**Application Reference:** 2025/0432

**Site Address:** 21 North Royds Wood, Athersley North, Barnsley S71 3NW

**Introduction:** Erection of part two storey, part single storey rear and side extension.

Rear Elevation
As Proposed

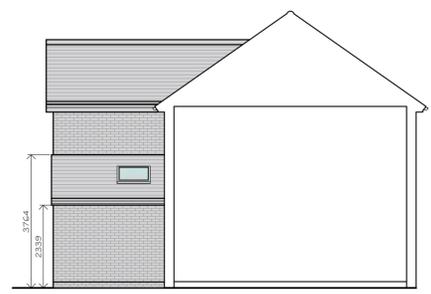
The proposed rear extension provides a rearward projection of approximately 3.2 metres. Single storey rear extensions are permitted up to 4 metres with an eave's height less than 2.5 metres. As such the single storey element of the rear extension is considered acceptable. Existing boundary treatment assists in screening the single storey extension to the north and south. Furthermore, neighbouring 23 North Royds Wood provides a rear conservatory extension with a larger rearward projection than the proposal. This reduces the impact of the rearward projection to the north. The proposed two storey rear extension provides a rearward projection of approximately 3.2 metres. The proposed projection is less than the permitted 3.5 metres under the Supplementary Planning Document for House

Extensions. A gable roof form is welcomed and is set down from the ridge, lessening the impact of the proposal. Furthermore, the two-storey element of the proposal is set in from the adjoining boundary by approximately 2.2 metres and by approximately 1.2 metres to the south. This further reduces the impact of the extension.

The side extension provides a significant setback of approximately 4.5 metres which assists in reducing the dominance of the proposal on the street scene. Both the single storey and two storey element of the side extension provides a pitched roof following the form of the existing roof. The proposal provides an approximate sideways projection totalling 2.4 metres allowing the proposal to be less than two thirds the width of the original dwelling and in line with the House Extensions SPD.

All glazing and door fenestration matches the original dwelling and is in keeping with the site. Matching materials have been detailed throughout.

Ground Floor Plan
As Proposed

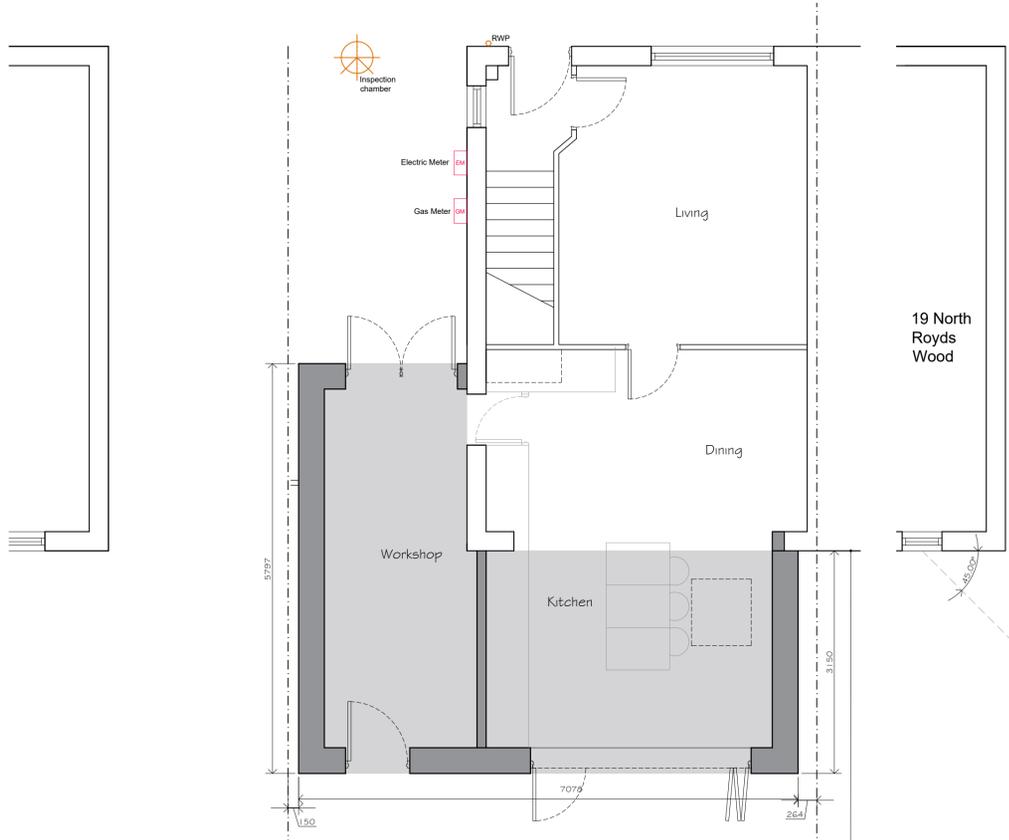
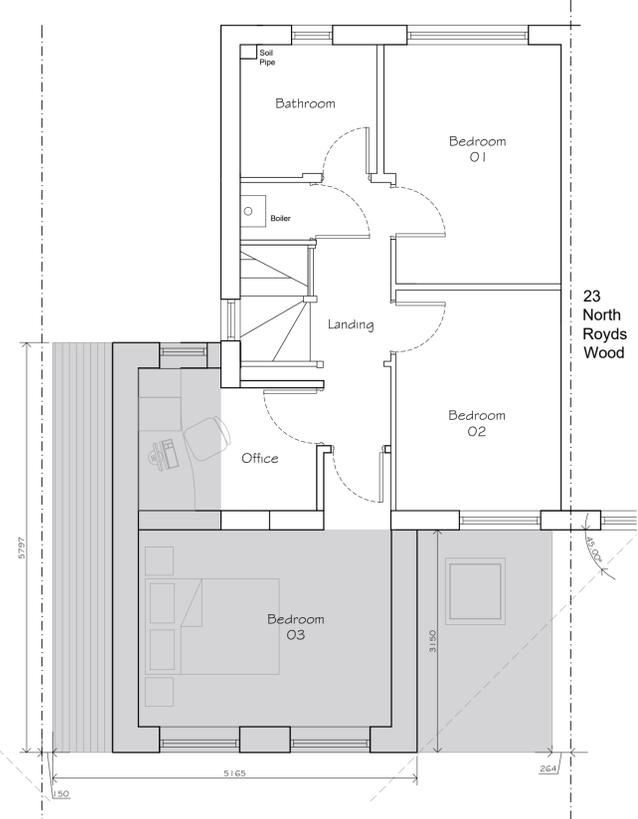
The proposed extension would be erected to the south of 23 North Royds Wood. The proposal is substantially screened by existing boundary treatment in addition to the existing neighbouring conservatory which prevents detrimental levels of overlooking and prevents any intersection at ground floor level of the 45 degree rule. No side windows are proposed with the exception of one roof lantern from which overlooking would not be possible. Windows at first floor level of the rear extension servicing the bedroom can provide levels of overlooking to the rear of the property, however this would not directly overlook neighbours to the north and south. Along with significant boundary treatment to the rear amenity space overlooking would not be to detrimental levels. The two-storey extension is set in by approximately 2.2 metres to the northern boundary which assists in preventing the extension intersecting the adjoining neighbours 45 degree angle. No detrimental loss of outlook is therefore caused by the proposal. The use of a gable roof form allows the nearest part of the two-storey extension to be at a reduced eaves height of approximately 4.9 metres which reduces both the dominance of the proposal along with any loss of light. Furthermore, no objections have been received in relation to loss of light or overdominance.

The side and rear extension would be erected to the north of 19 North Royds Wood. No windows are detailed to the side elevations providing little opportunity for levels of overlooking. Given the proposal is to the north there will be little opportunity for loss of light to the south as a result of the proposal. It is acknowledged the proposed side extension would have an impact on neighbouring 19 North Royds Wood, however, given the proposal is further set in at two storey level, the dominance is reduced. Furthermore the proposal does not intersect the 45 degree angle of this neighbours nearest rear window, preventing any loss of outlook.

The proposal does not result in the increase of bedroom facility at the site. Parking space is reduced however parking facility for two cars is maintained due to the significant setback of the proposal. As such the proposal is considered acceptable in terms of its impact on highway safety and in compliance with Local Plan Policy T4 New Development and Transport Safety. This carries significant weight in favour of the application.
